Transport
Roads & Maritime
Services

WST11/00087

Coalpac Expansion Modifications; DA-200-5-2003 MOD 2 and 07_0127 MOD 4

Thank you for your email received 26 February 2014 referring a draft Environmental Assessment for Coalpac Expansion Modifications to Roads and Maritime Services for submissions.

Figure 8: Existing and Proposed Water Pipeline Alignment

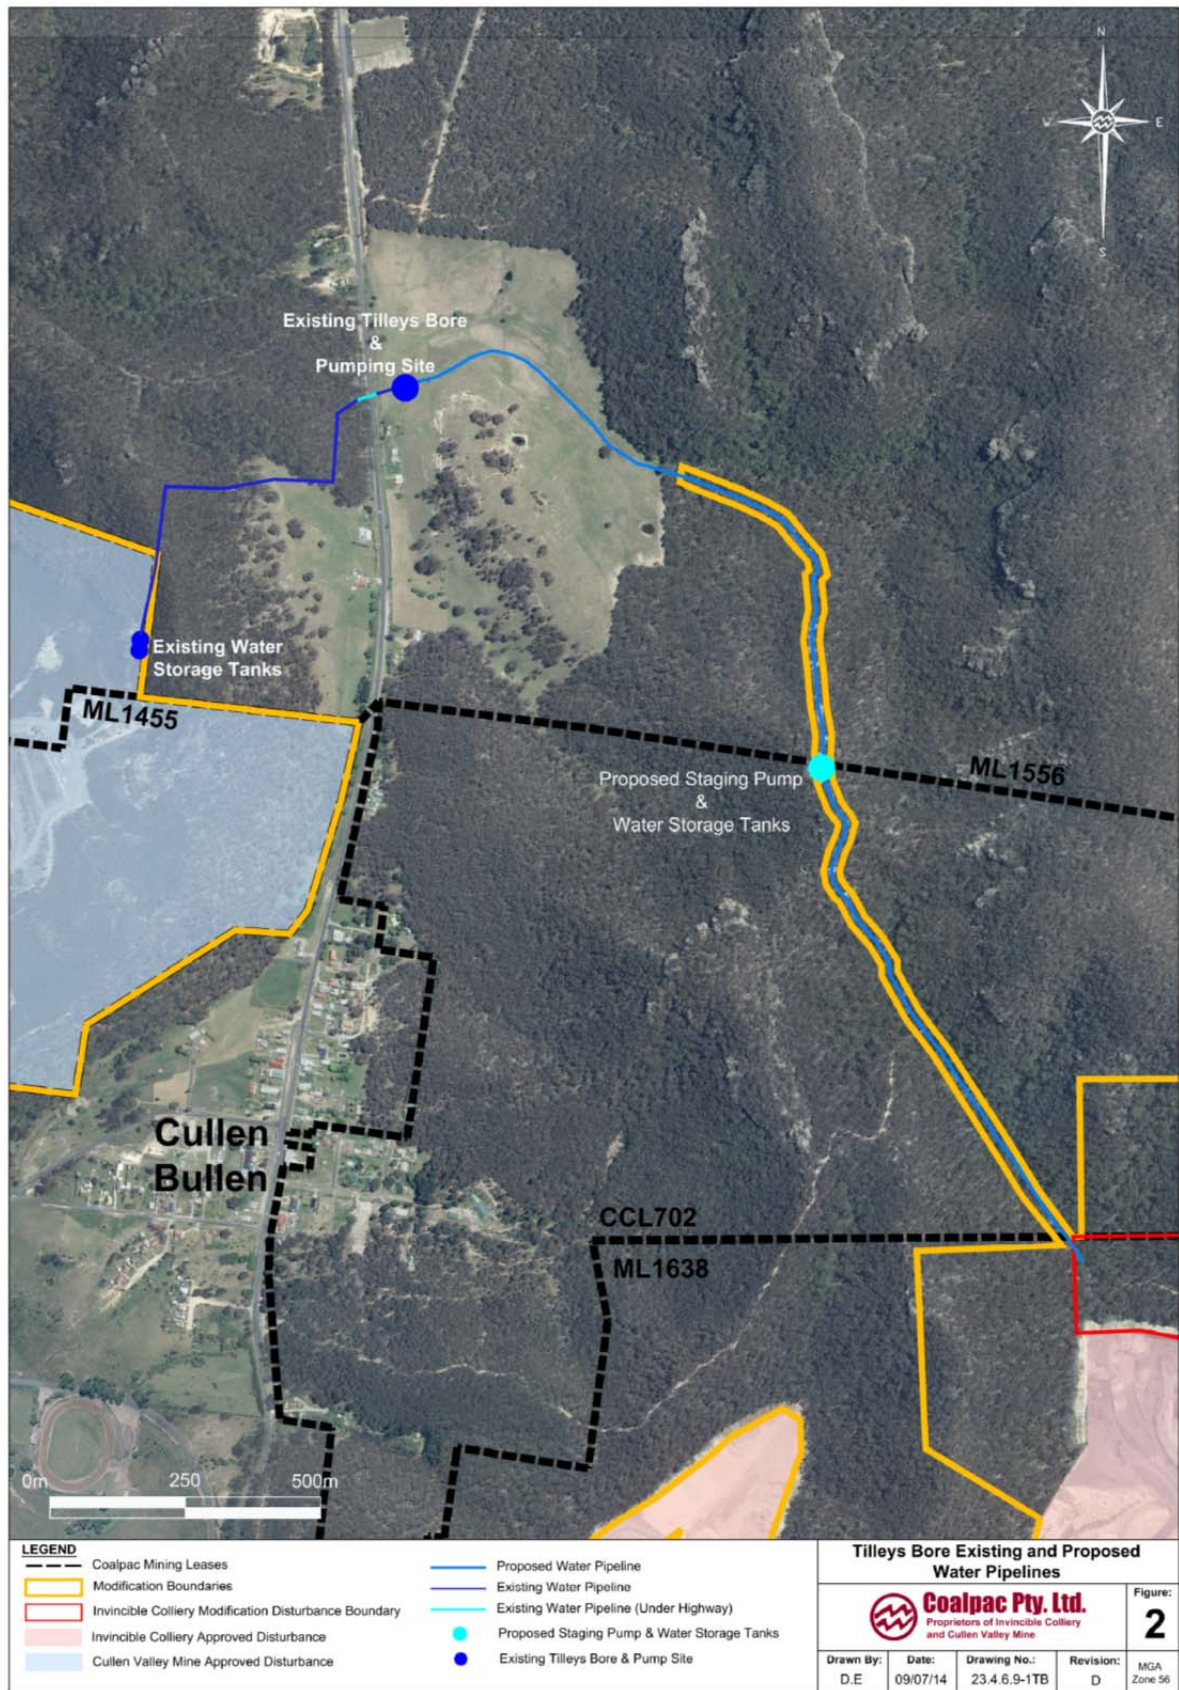
- The draft Environmental Assessment refers to a water pipeline connecting Invincible and Cullen Valley however no details are provided for crossing of the Castlereagh Highway. Roads and Maritime concurrence is required for a pipeline crossing, requirements can be provided upon request. Details of the crossing location would be required for assessment.
